From: Bernie Harverson [REDACTED]
Sent: 01 October 2017 17:53
To: Michael Eastham
Cc: Richard Martin; Joe Russell-Wells; Sue Howell
Subject: A/99/17/OUT - Land south of Water Lane, Angmering

Planning Application: Seeking advice on an **OUTLINE** planning application for this site for 175 residential units

Reference: A/99/17/OUT

Location: Land south of Water Lane, Angmering

Tree Protection Plan

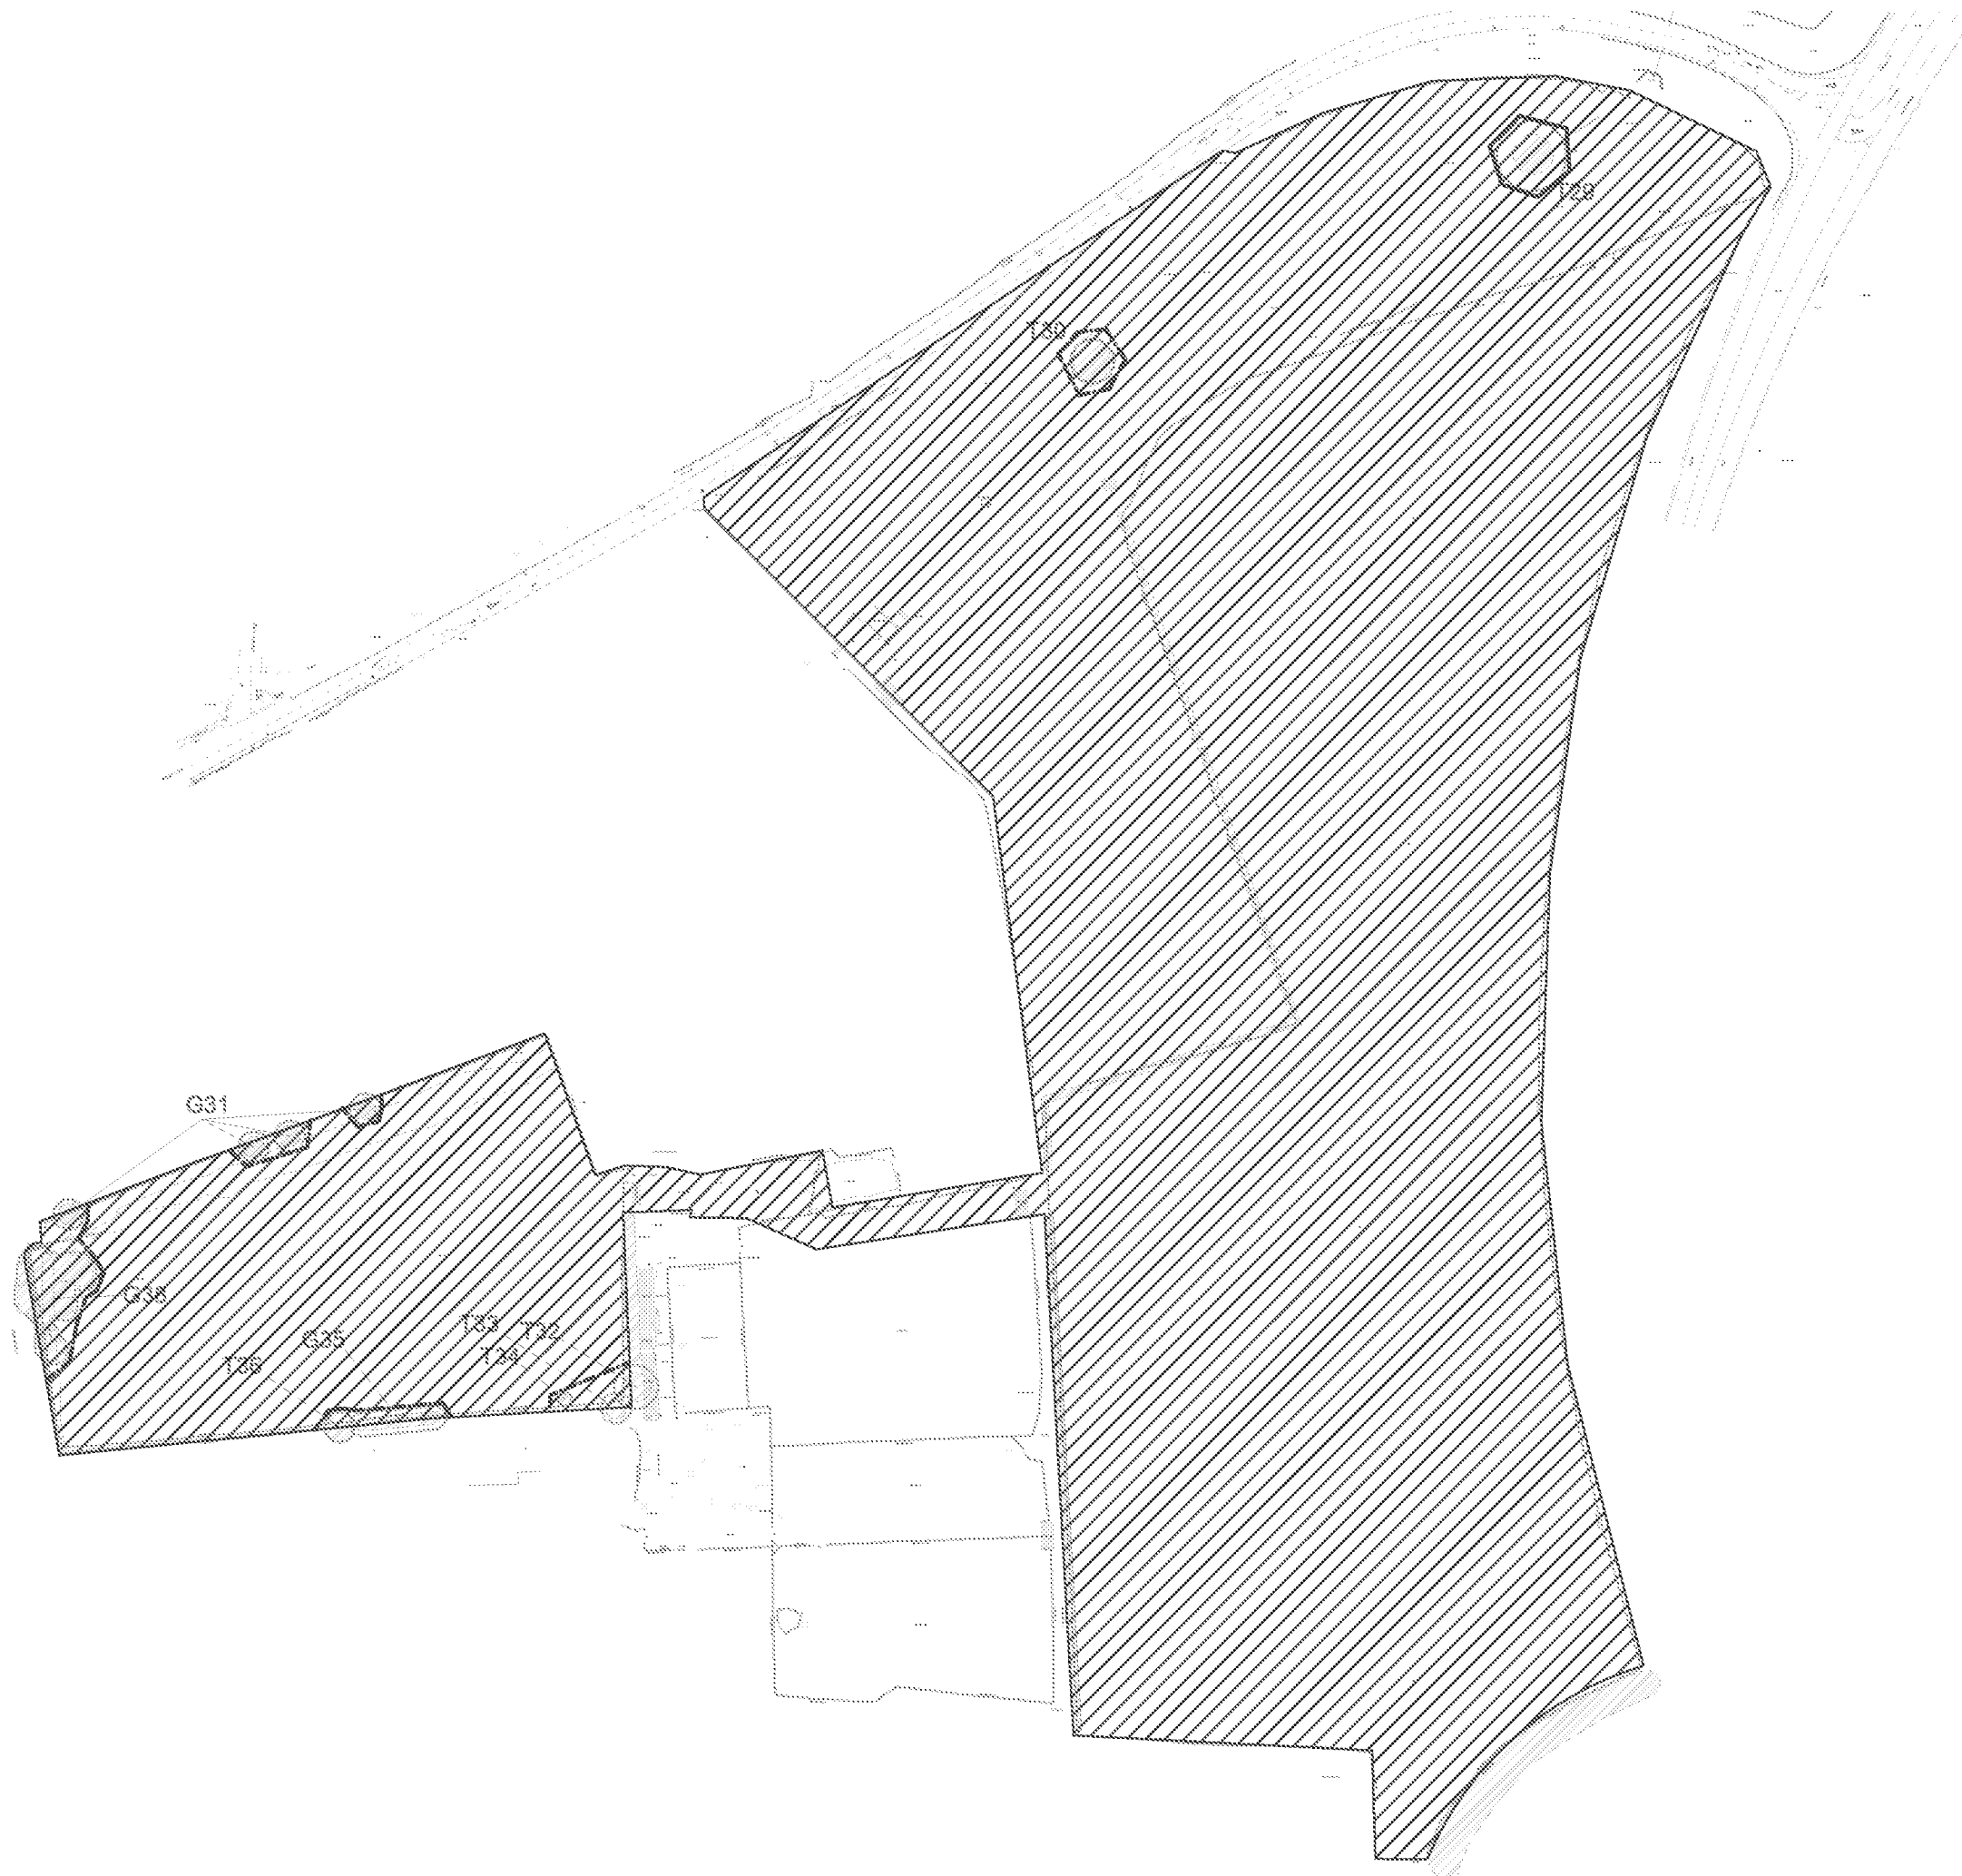
- However, despite there being an Illustrative Masterplan 1911/PO3 Rev E in existence in June 2016 the AMS report does not reference this document and is very generic in nature and furthermore the Tree Protection Plan is not acceptable because it has to be drawn onto the masterplan base so that I can assess the true impact that it will have on the retained trees – instead it is drawn onto the red line site boundary drawing.

Drawing title: Tree Constraints Plan

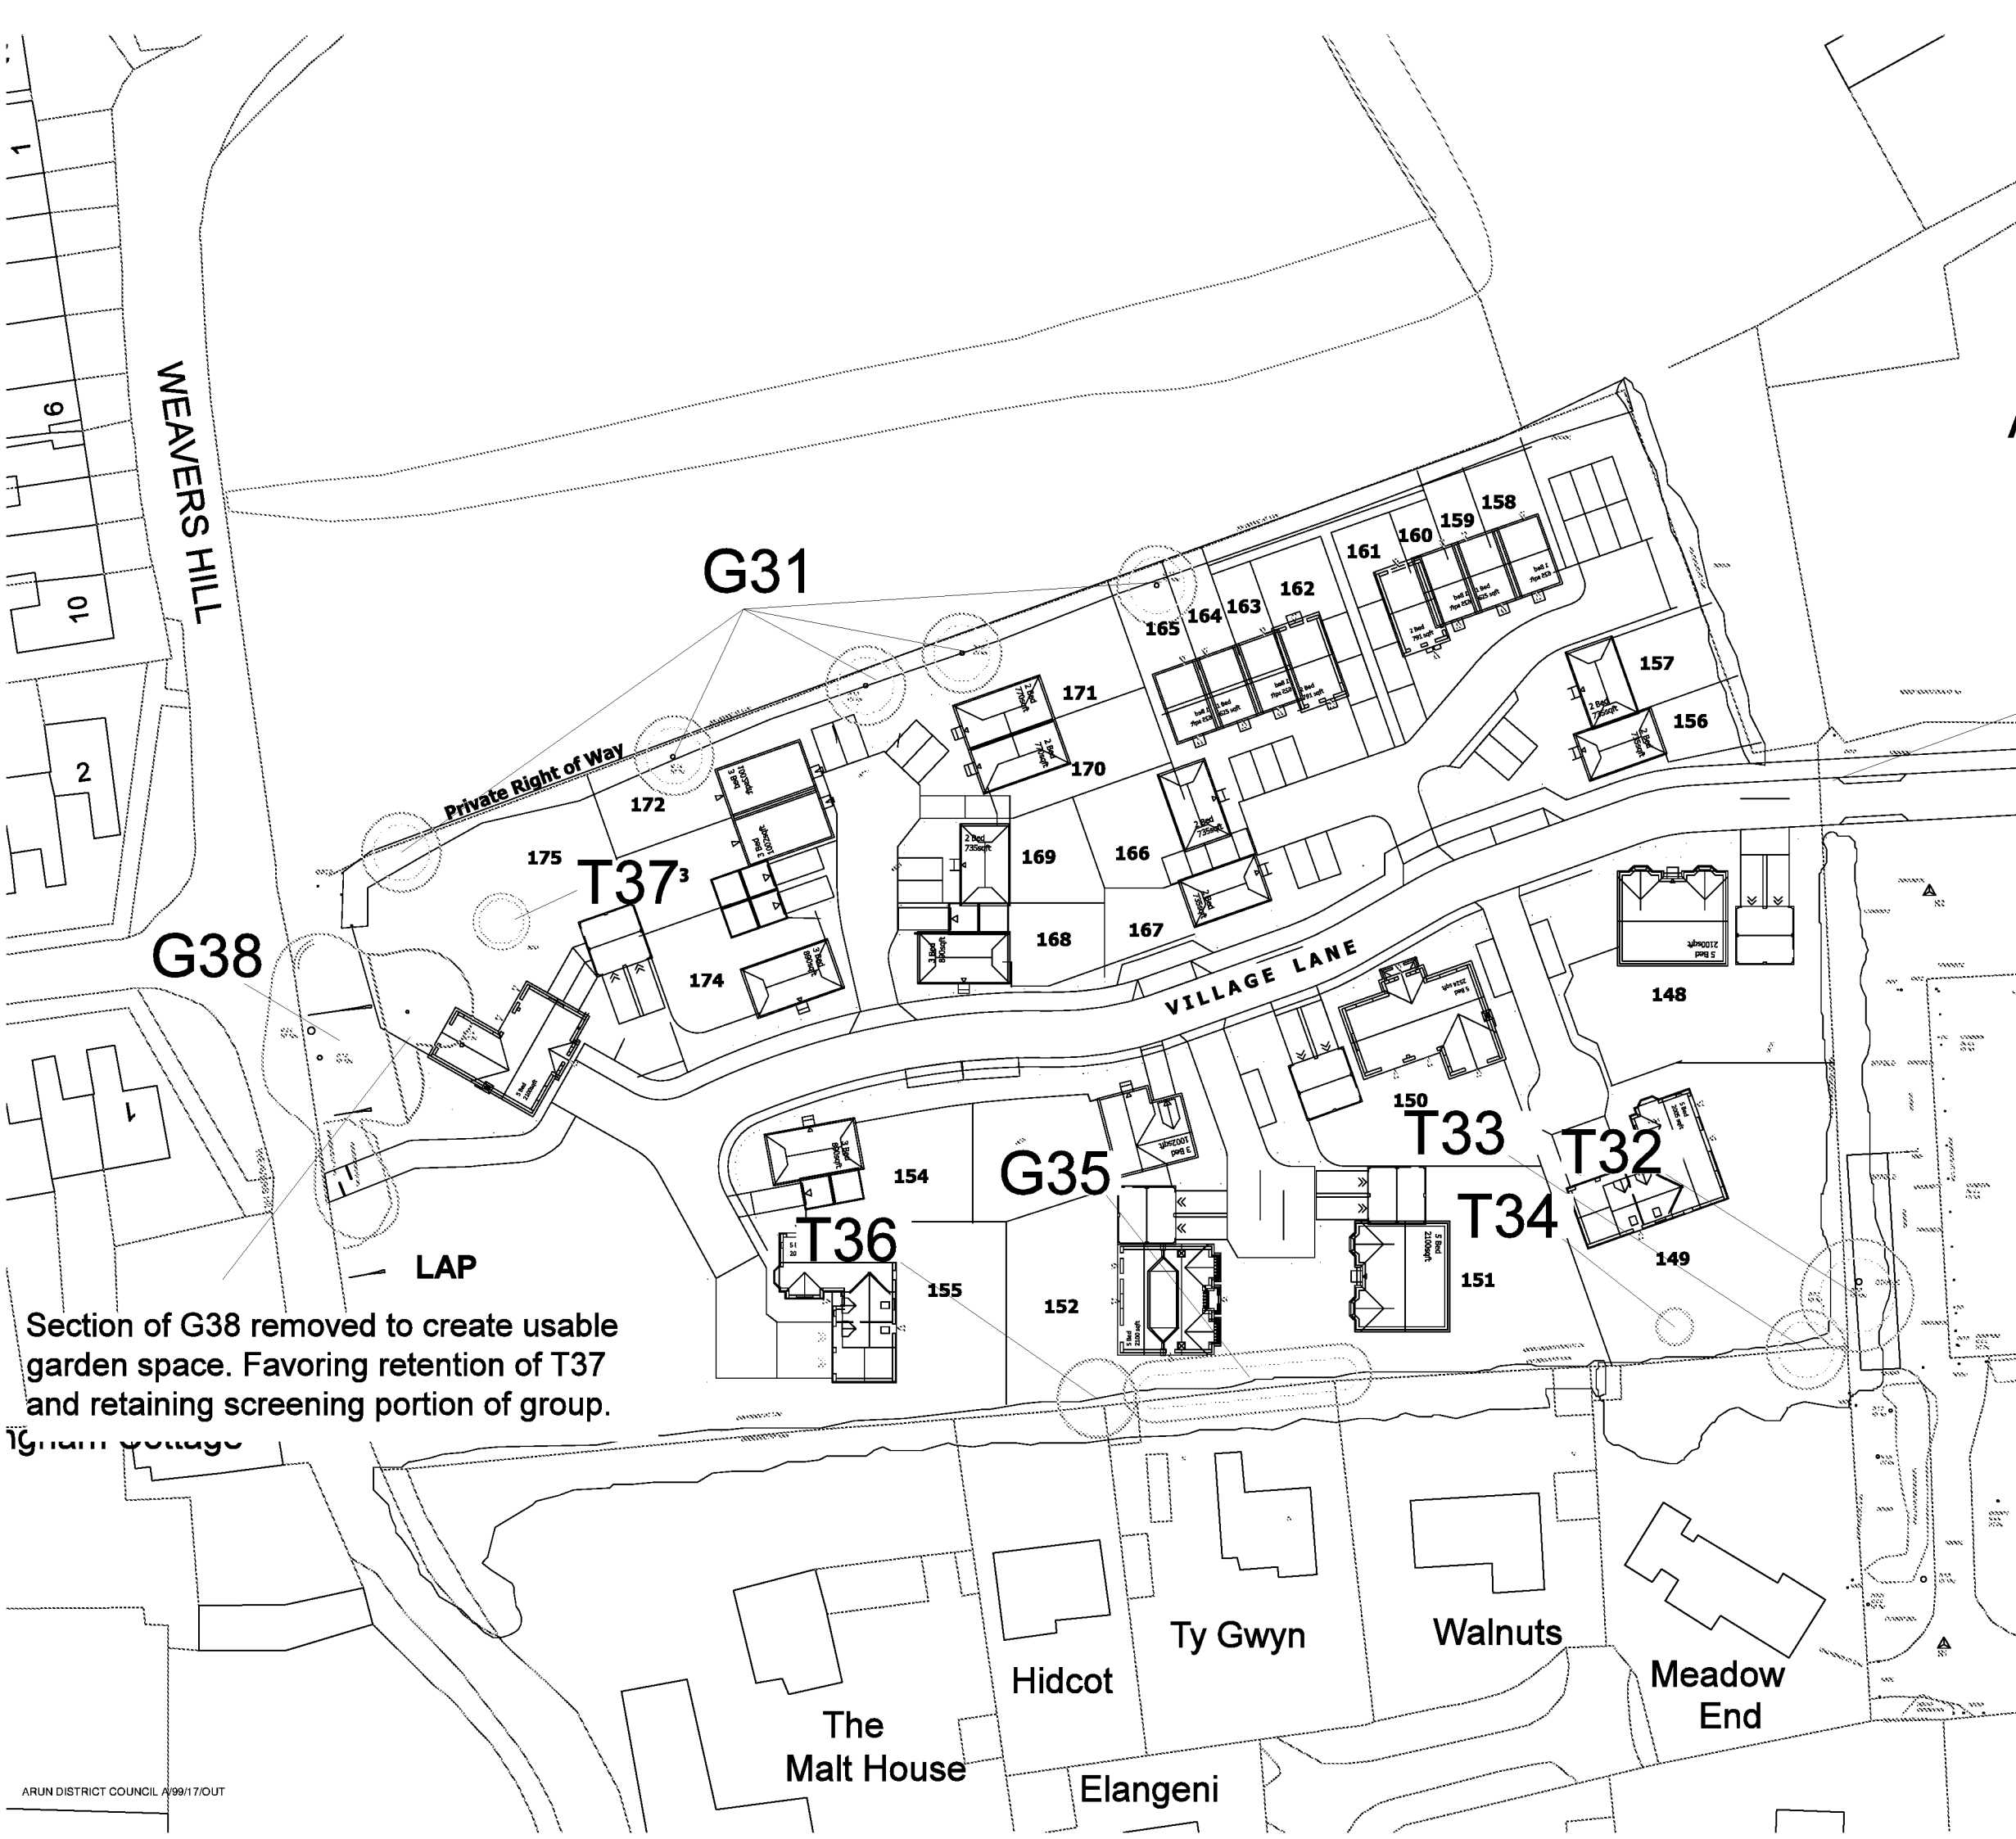
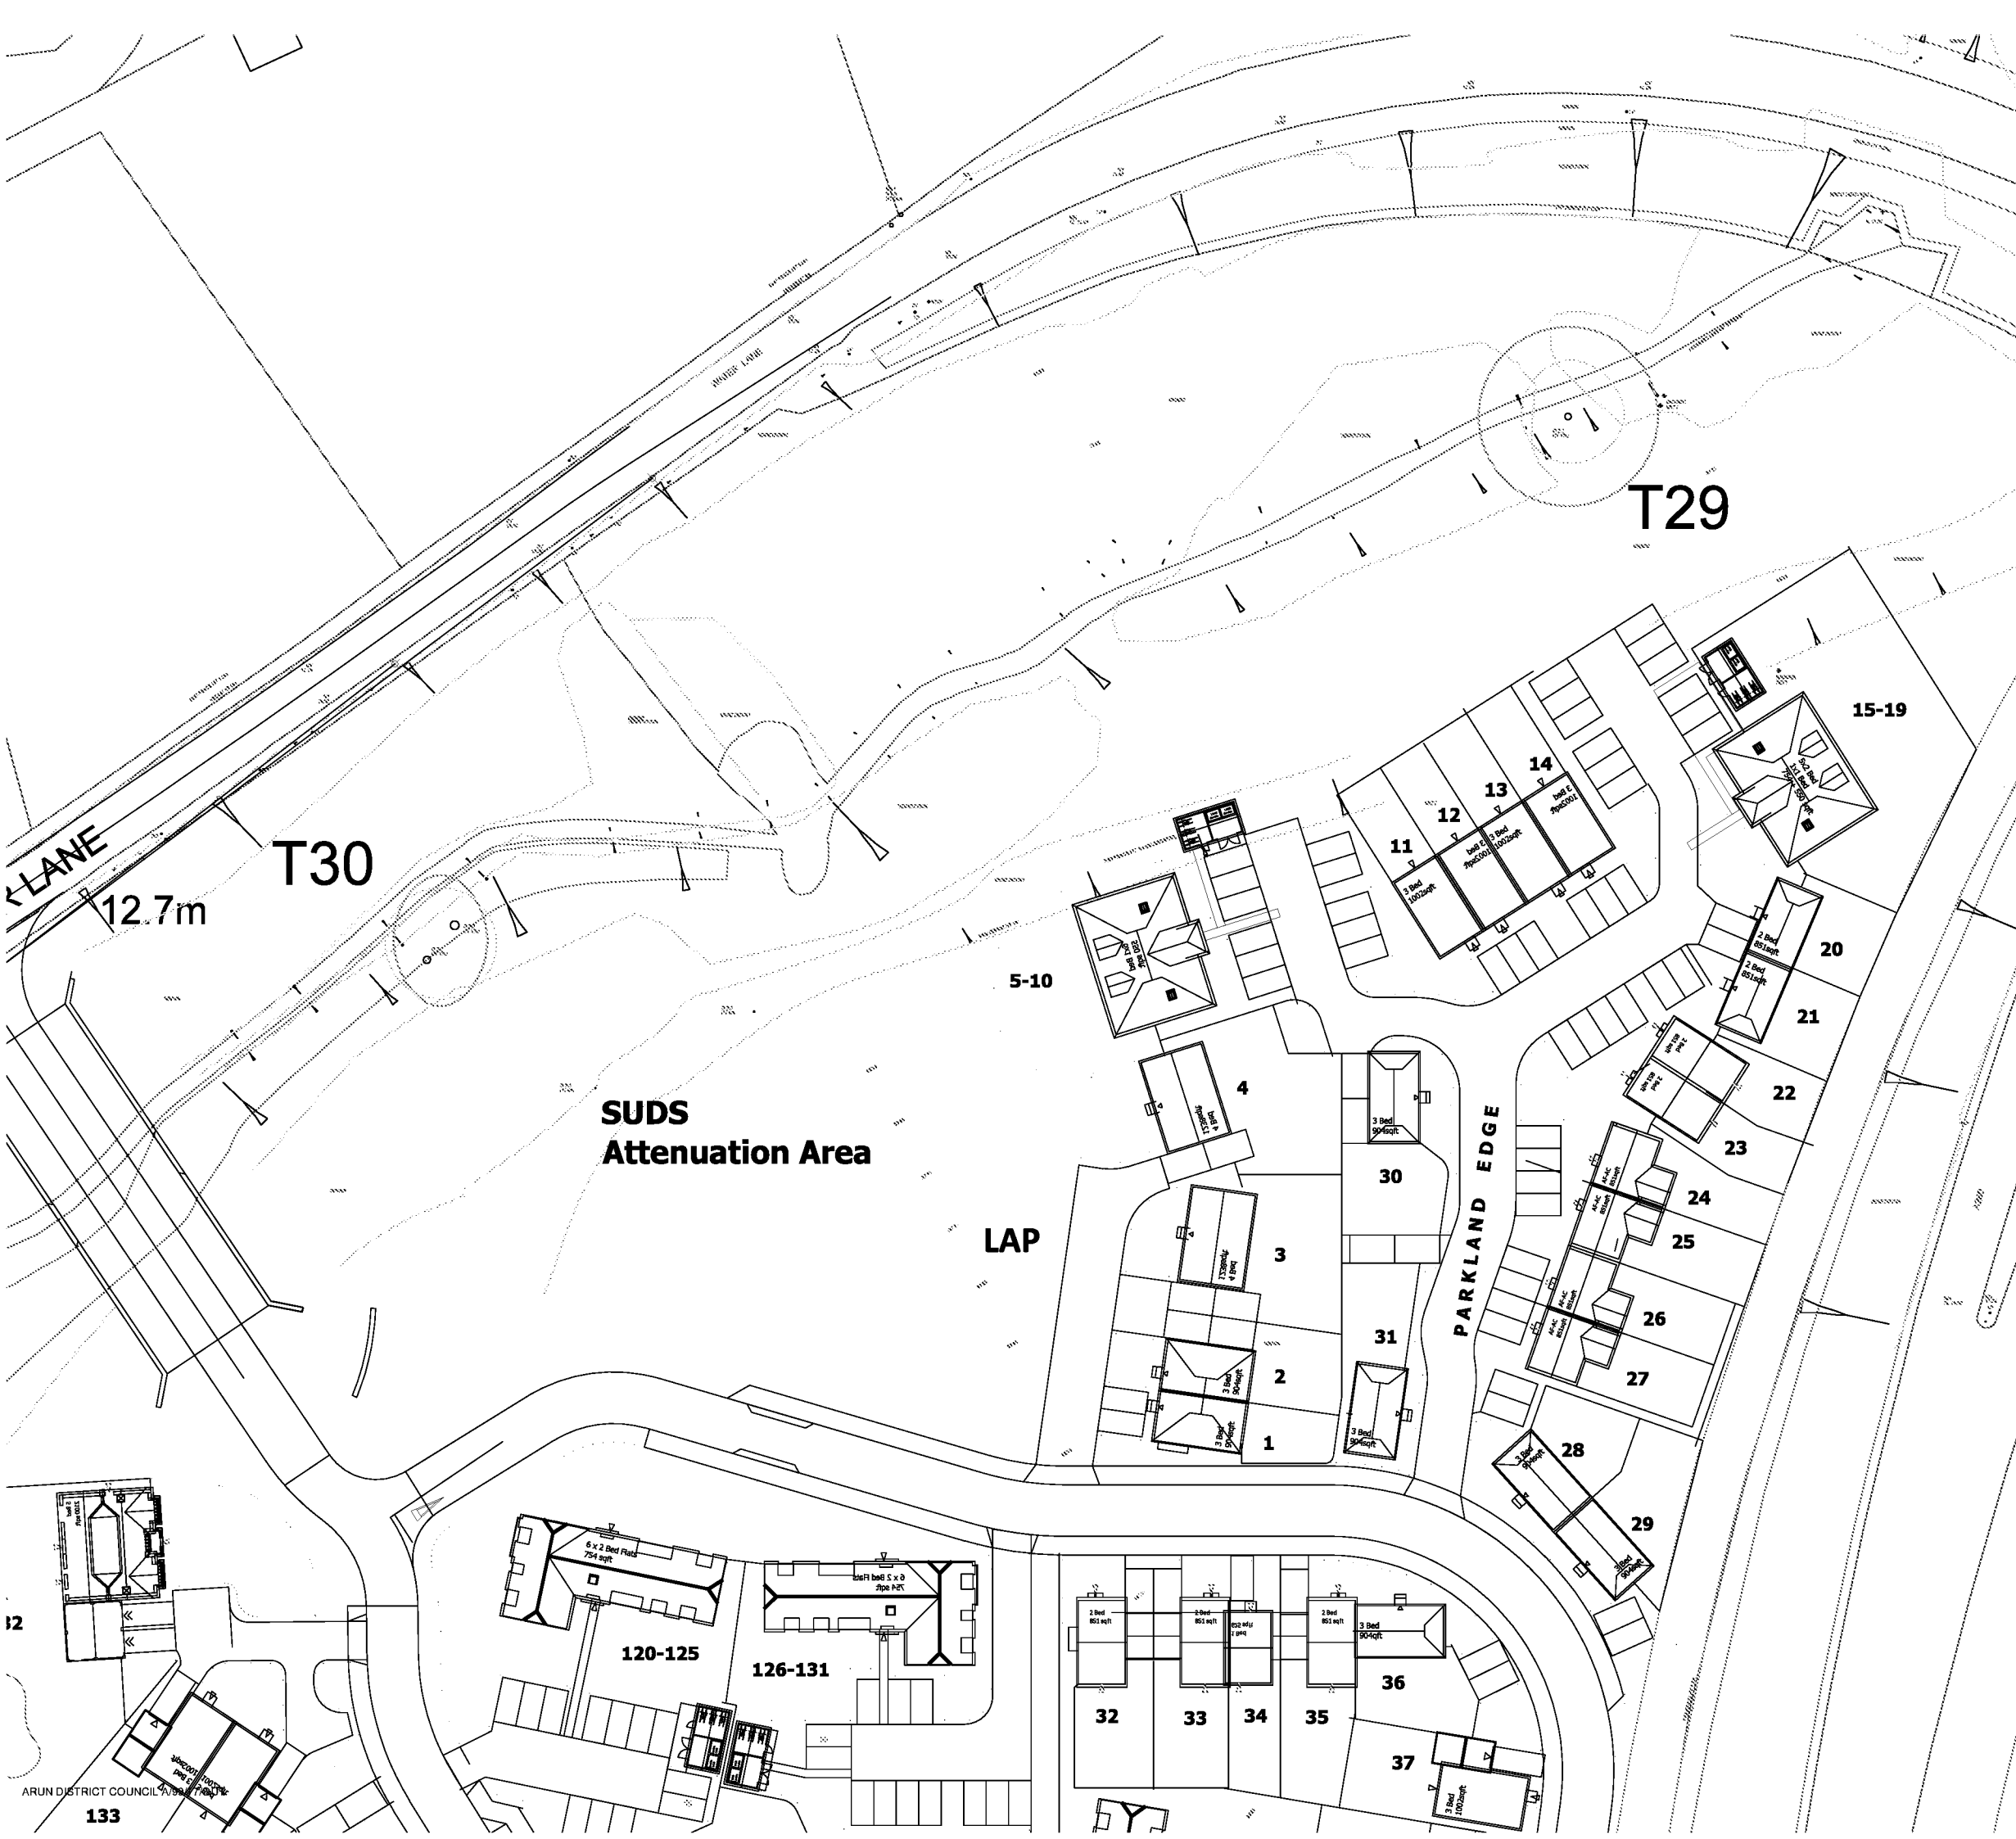
- In my review of the Illustrative Masterplan 1911/PO3 Rev E I note that in Plot 175 it shows a large garden area and no access out onto Weavers Hill and yet the PJC AIA says that it will be necessary to remove the good young specimen Oak T37 – I cannot see the justification for this!

- Plot 171 & 172 place pressure on two young Lime trees in Grp 31 and whilst I note that they suggest the removal of one of these trees the other one is proposed for retention and this would be under immediate pressure to be 'pruned or felled' given that it is a young tree with significant growth potential for the future.

- Further to this the access drive and parking bays will overlap the RPA of another retained Lime in this group and yet this is not mentioned in the AMS report?
